August 5, 2003

**Re: Dental Office  
Traffic Circulation Layout (J-16/D16)**

Based on the information provided in your submittal received 7-30-03, the above referenced plan cannot be approved for Building Permit until the following comments are addressed.

**C.1**

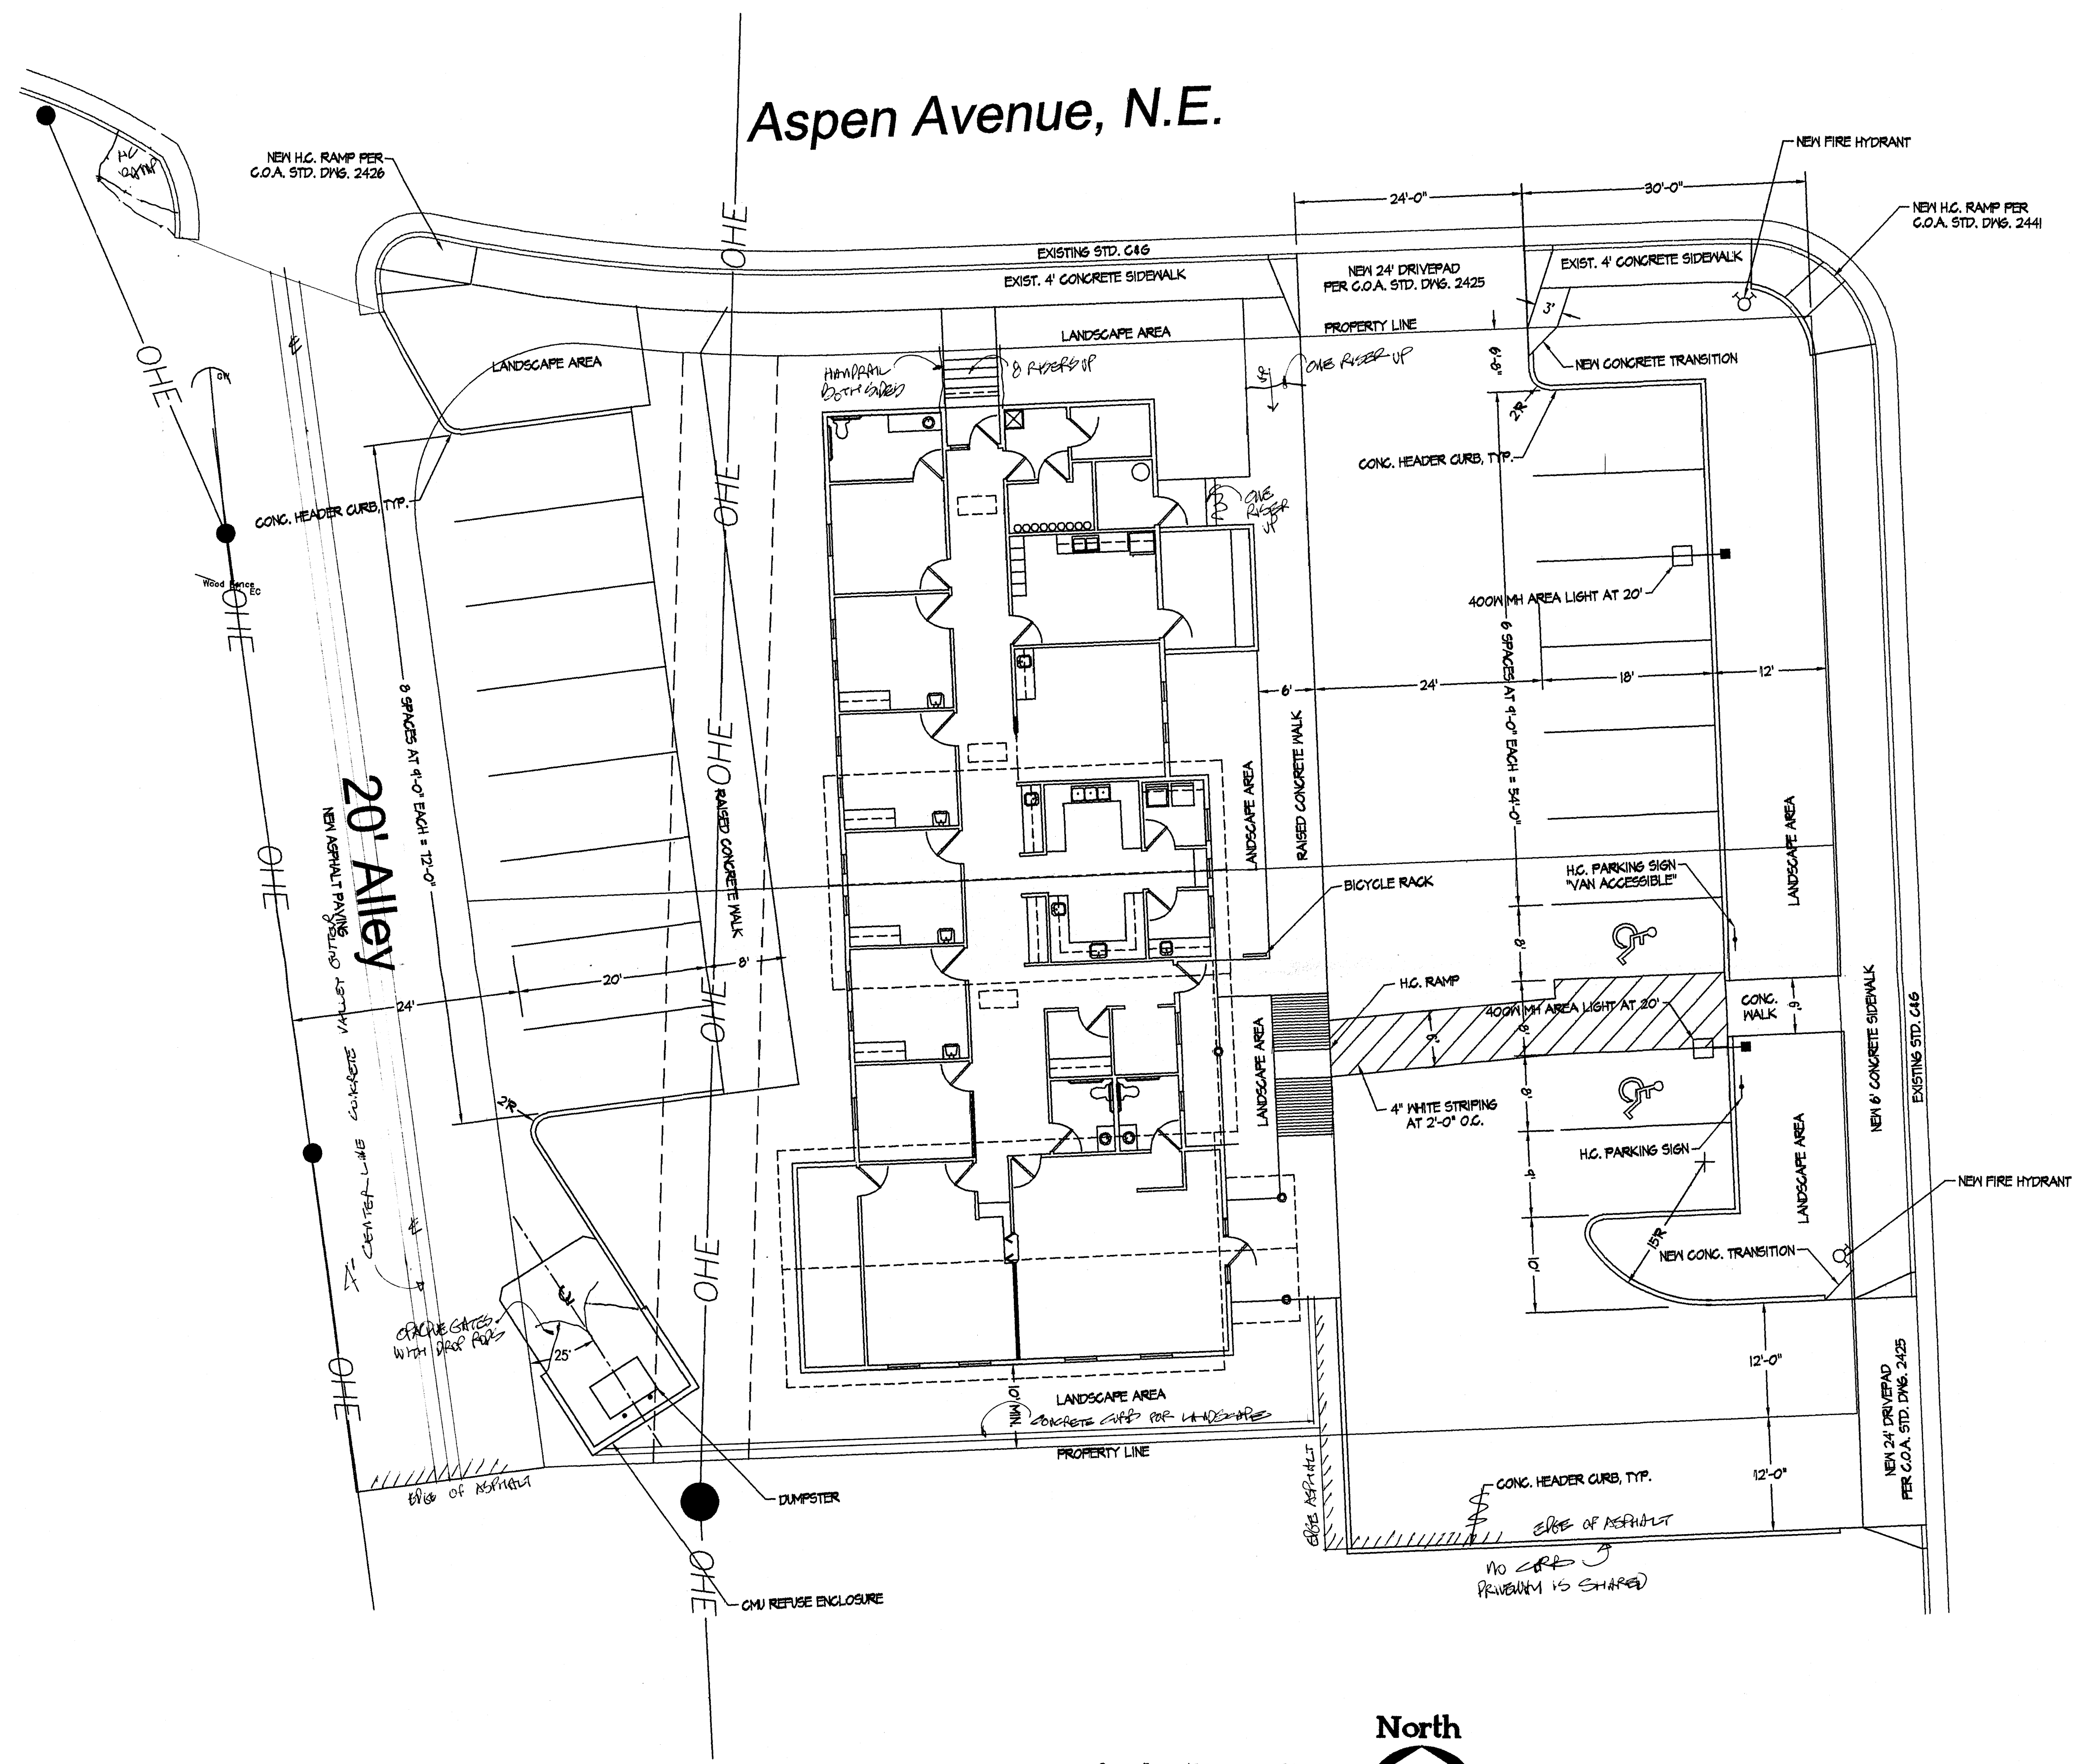
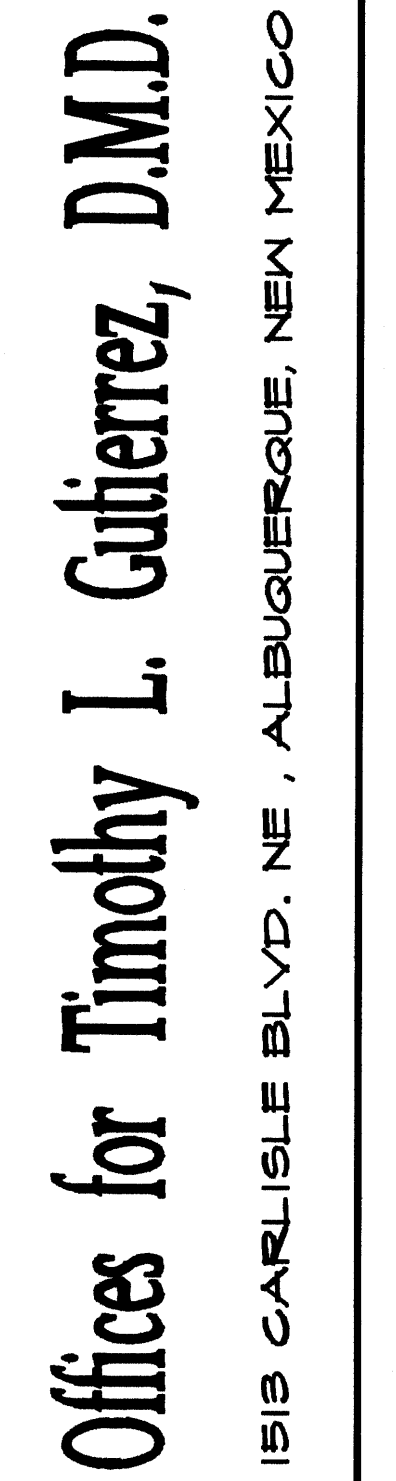
- Architect's stamp must be signed and dated.
- Please show all curb radii.
- Please show dimensions of handicap parking spaces.
- Per sidewalk ordinance, a handicap ramp must be installed at the corner and at the alley, if there presently isn't one.
- The curb adjoining the refuse enclosure must be extended westward to prevent parking which could block dumpster.
- Sidewalks need to be transitioned to proper location for ADA accessibility through drive-pads.
- A shared access agreement or easement for Carlisle driveway is required.
